Ref: SSD-77825469

RE: OBJECTION TO SSD-77825469

Thank you for the opportunity to comment on State Significant Development Application (SSD-77825469) for demolition of existing buildings and construction of a residential apartment development with 178 apartments, including 39 affordable housing apartments, above basement car parking, tree removal and lot consolidation. At No. 2 – 16 Pockley Avenue, Roseville.

Ku-ring-gai Council's objection to SSD-77825469 at No. 2 – 16 Pockley Avenue, Roseville.

Figure 3: Height Plane Diagram (Woods Bagot)

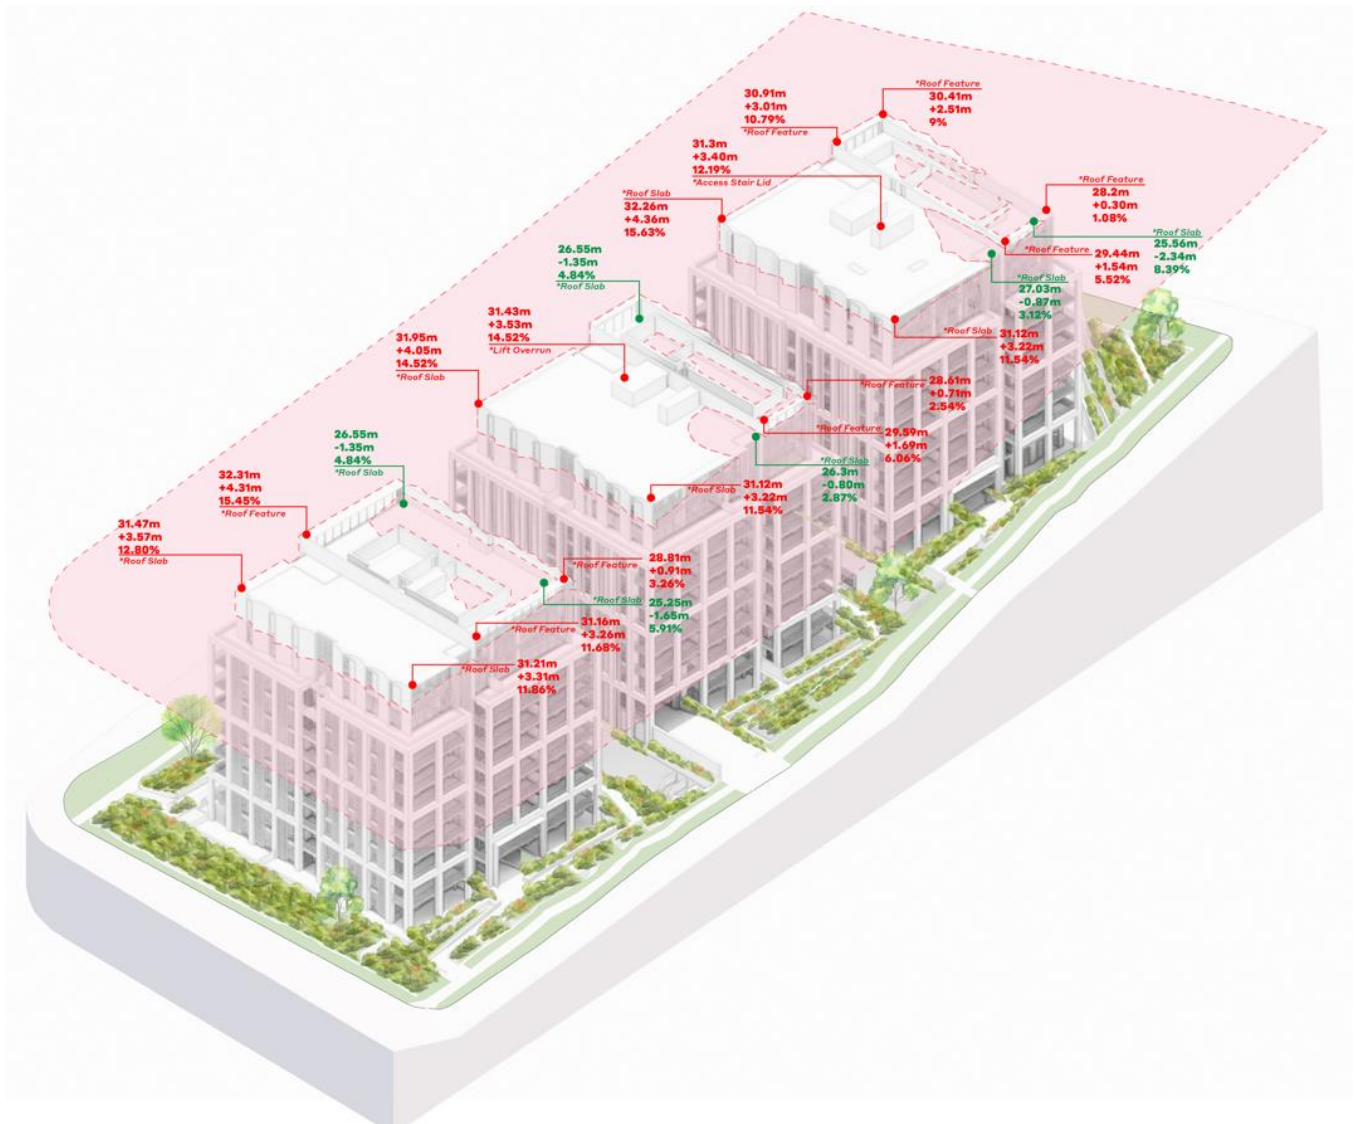
The impact of the non-compliance is most notable along the western profile of each building and equates to 3.57m increase Building C, 4.05m increase Building B and 4.36 increase on Building A. In Ku-ring-gai and in throughout Sydney more broadly, topographic steepness is a key factor contributing to many sites. It is therefore a key characteristic to be responded to positively rather than a constraint to be overcome or varied.

The Clause 4.6 seeks to vary the maximum building height (27.9 metres) by 4.41 metres (15.45%), resulting in a maximum building height of 32.31 metres.

The Clause 4.6 has failed to give any consideration to the objectives in Clause 4.3 in KLEP. The objectives in Clause 4.3 in KLEP deal directly with building height and should be considered in order to demonstrate whether strict compliance is “unreasonable and unnecessary” The variation request argues that compliance with the development standard is unreasonable and unnecessary for various reasons. Relevant extracts of the variation request are provided below:
